**Consultation Response from KC,
 Lead Local Flood Authority**
2021/93674 Greenhead College, Greenhead Road, Huddersfield, HD1 4ES
Partial redevelopment of Greenhead college including demolition and making good, erection of 2 and 4 storey buildings, reconfiguration of parking and access arrangements, reconfiguration of sports provision and other associated external works (Within a Conservation Area)
**Date Responded:
 27/10/2021**
**Responding Officer:
 Martin Stephenson**
**Responding Ref:
 1**
Drainage comments

Drawing No.
NE8659-CCS-ZZ-XX-DR-D-0501

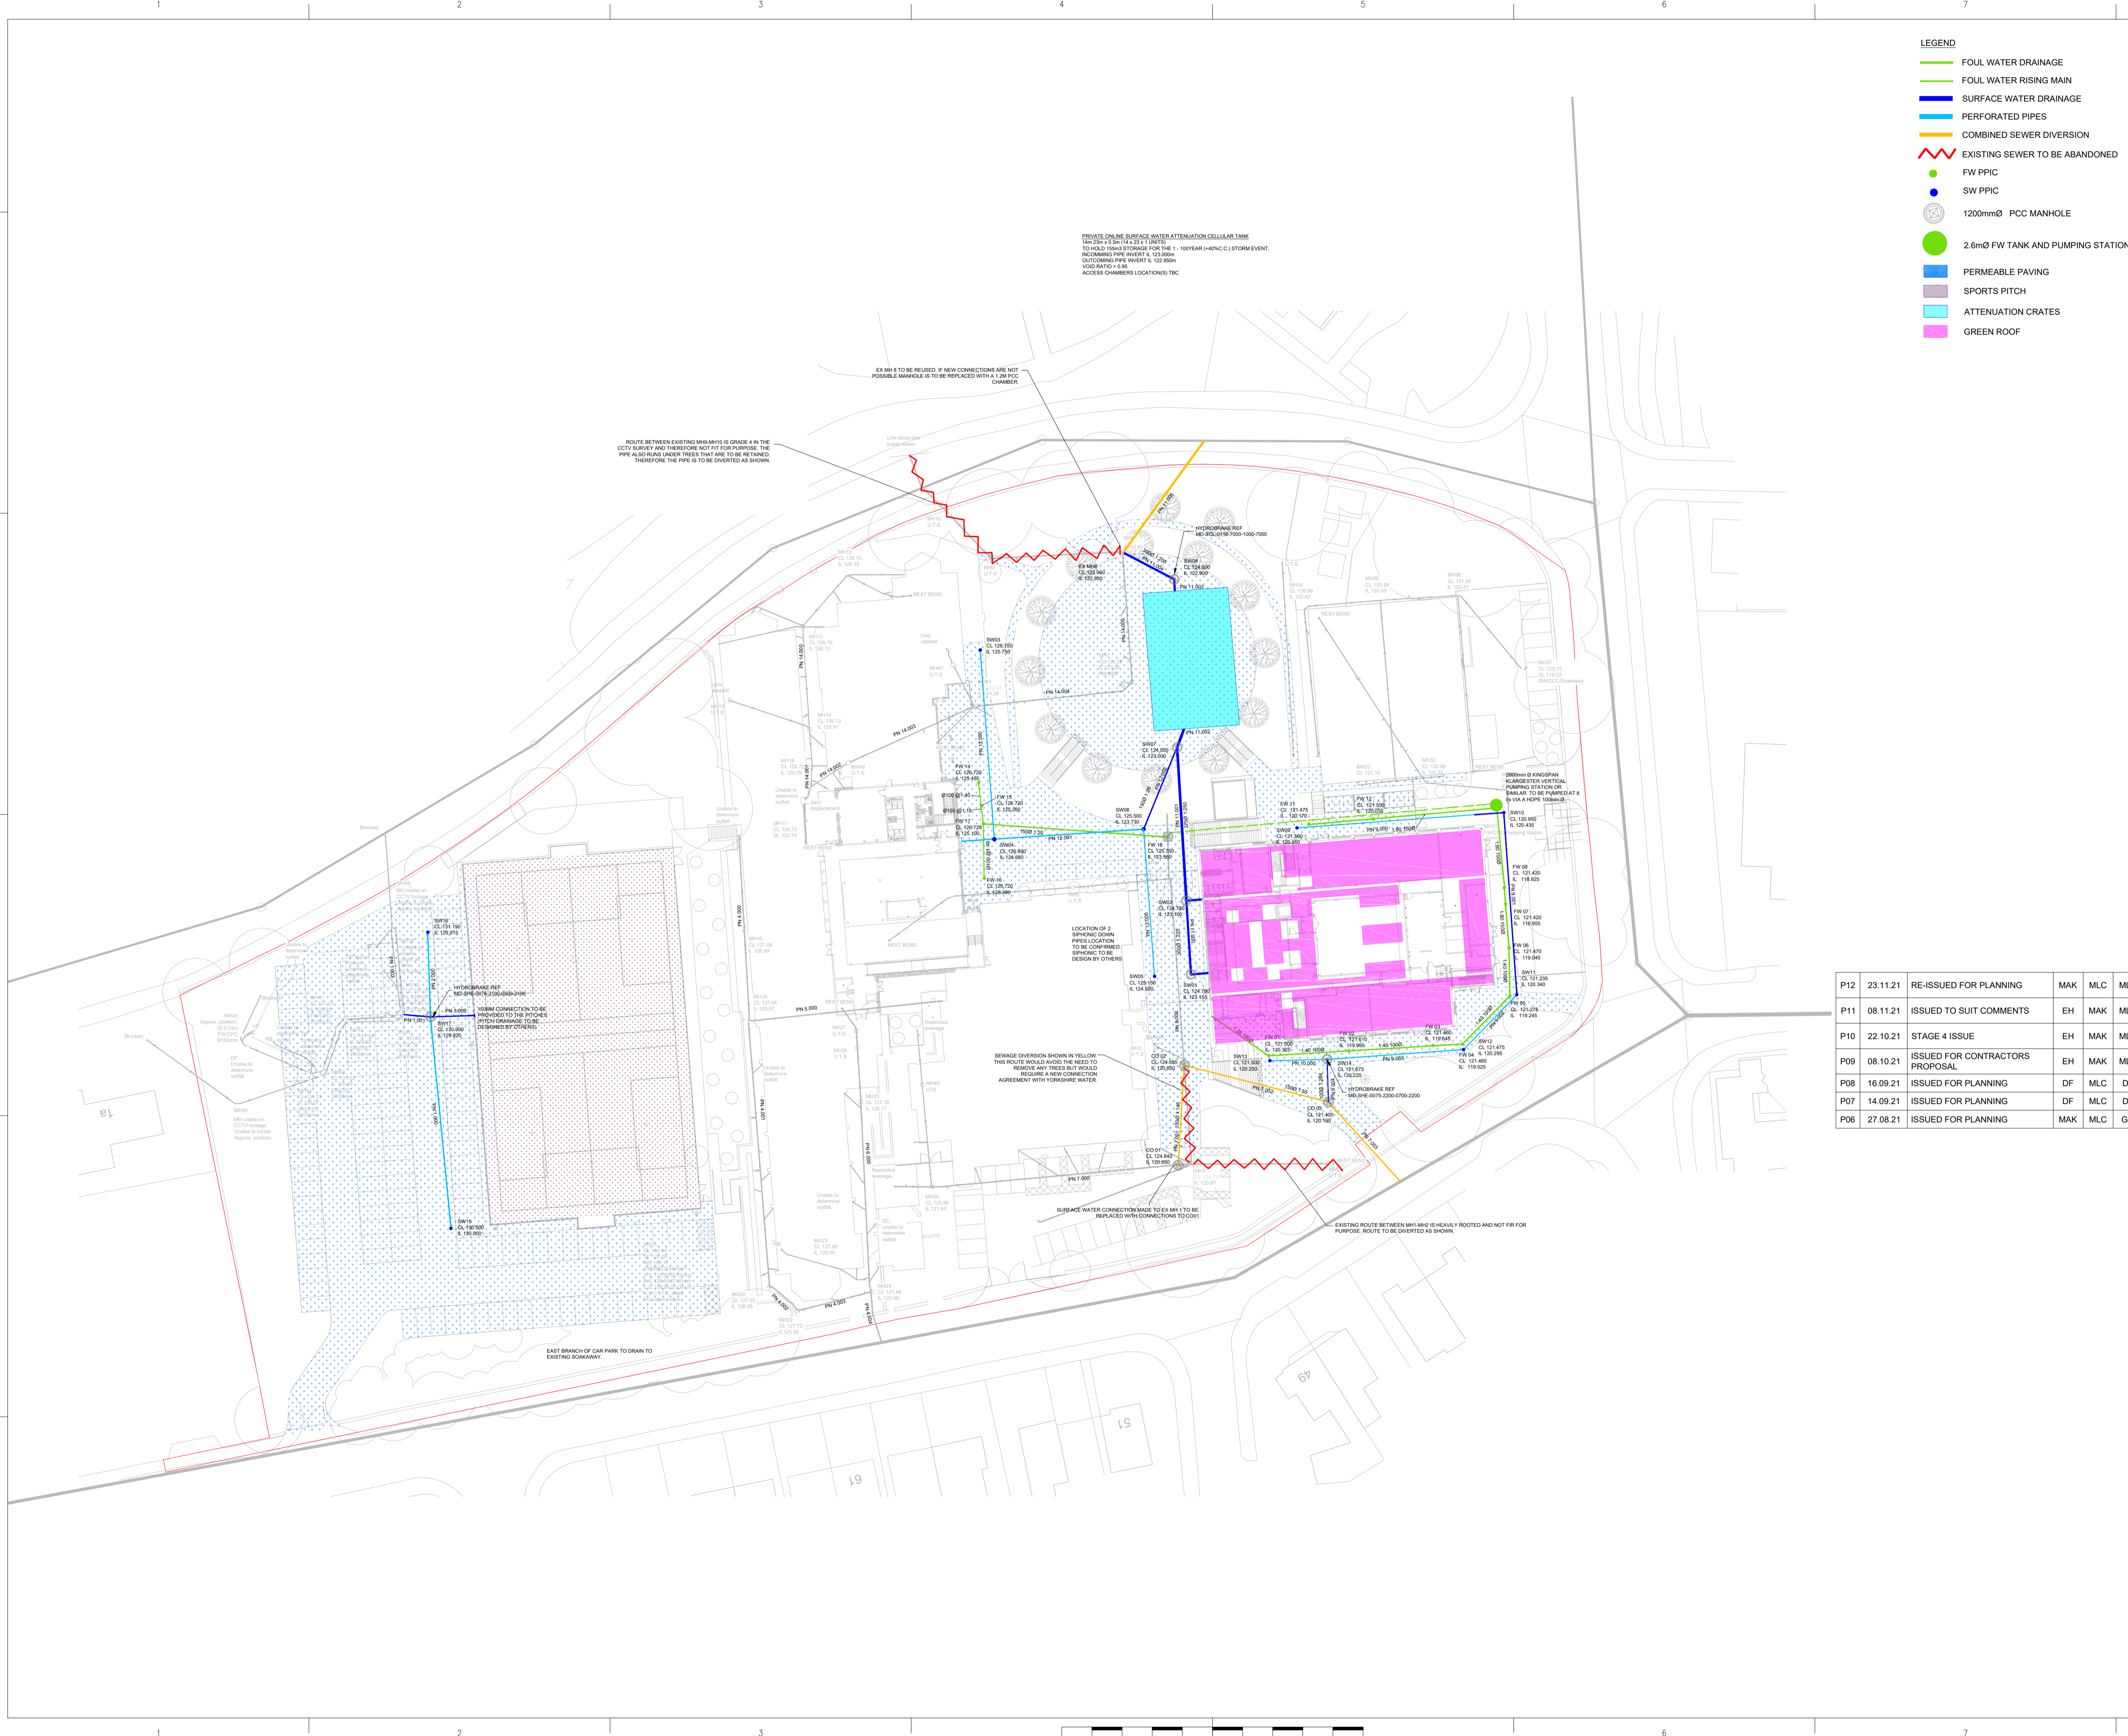
The MicroDrainage Calculations issued 11/11/21 and drainage drawing ref: NE8659-CCS-ZZ-XX-DR-D-0501 P13 issued 09/12/21 as part of the revised FRA are now acceptable to the LLFA.
